Submission Form

Epping to Thornleigh Third Track Proposal. Application number SSI 5132.

Figure 5.6 Cross-section and elevation - New Cheltenham Station concourse building
Note: Indicatively added to future design

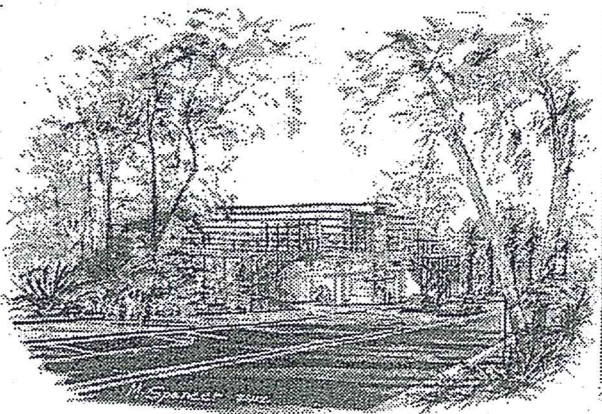
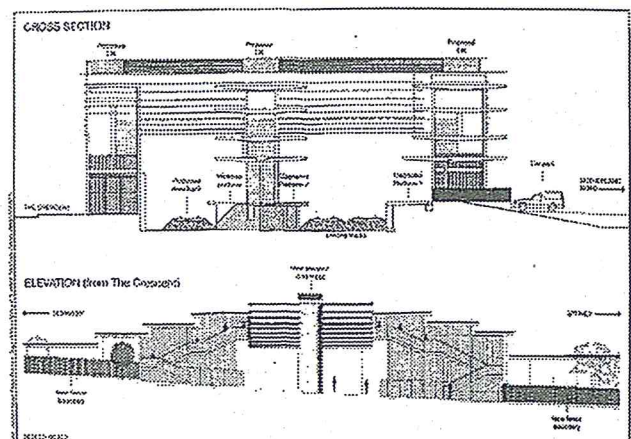
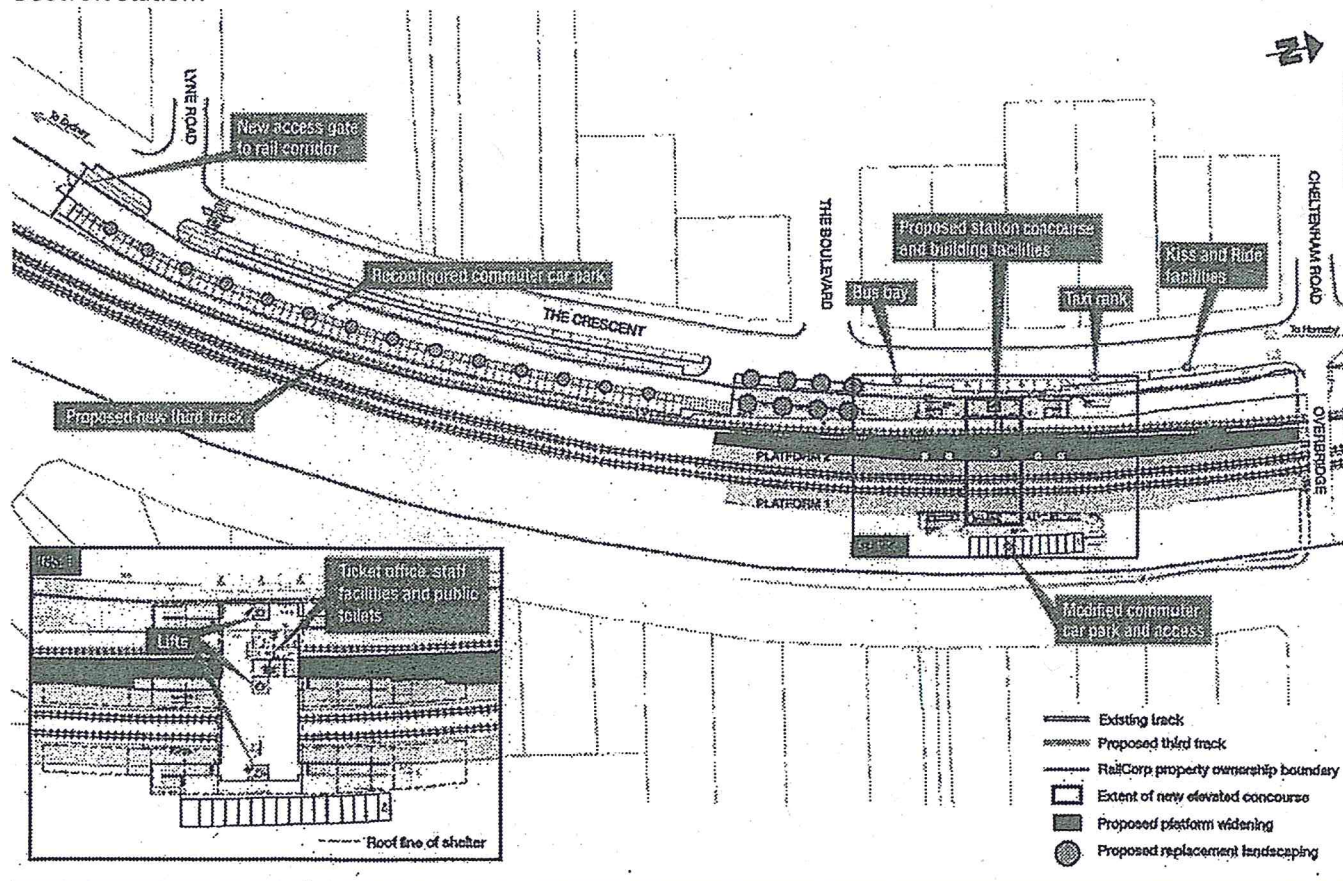
- The proposed redevelopment of Cheltenham Station shows no regard for the HCA. The visual impact of the proposed 13m high glass and steel concourse is totally unacceptable in this HCA.
